From: Trees Planning
Sent: 15 November 2017 13:45
To: DCAdmin
Subject: 2016/92298 - Former North Bierley Waste Water Treatment Works

Nick Goddard
Arboricultural Officer

ILLUSTRATIVE MASTER PLAN

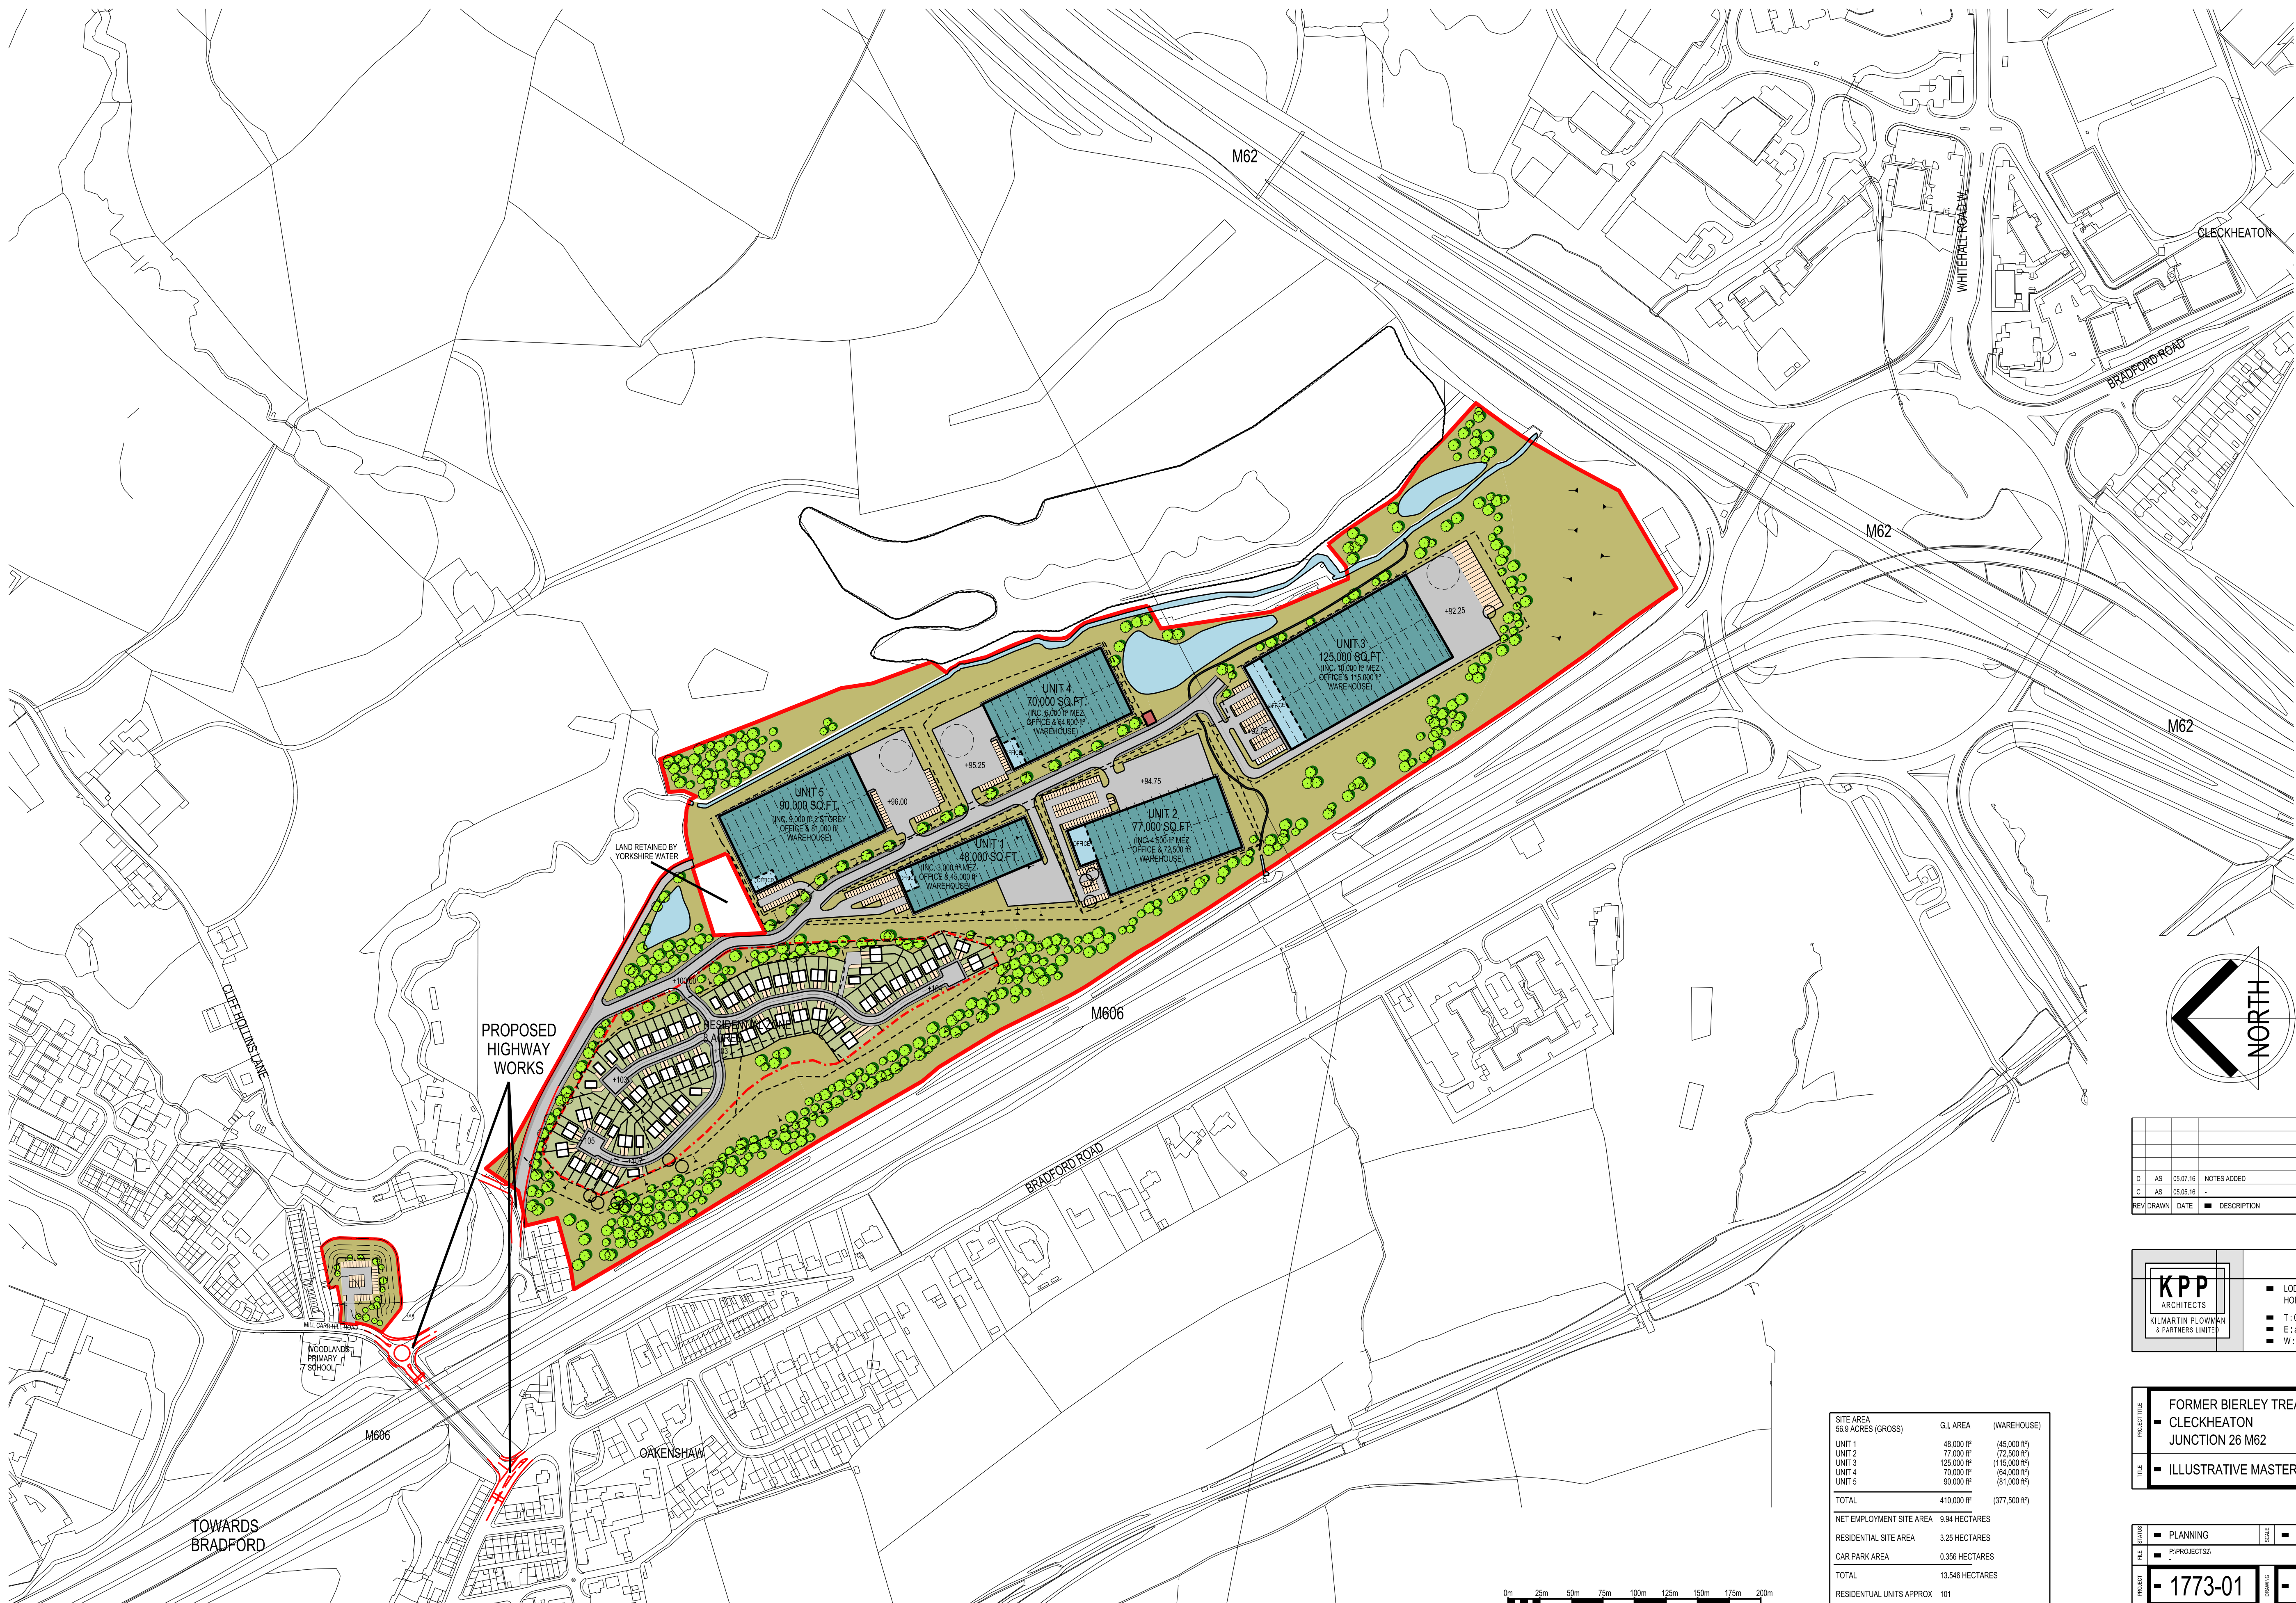
The proposals give provision for a buffer of approximately 10m from the adjacent ancient woodland, Hanging Wood. However as the guidelines from Natural England are 15m standoff to all ancient woodlands the tree survey and method statement would need to address how the woodland can be protected both during construction and following completion.

I would be happy for this information to be provided as part of a reserved matters application and therefore have no objection to the proposals at this Outline stage.
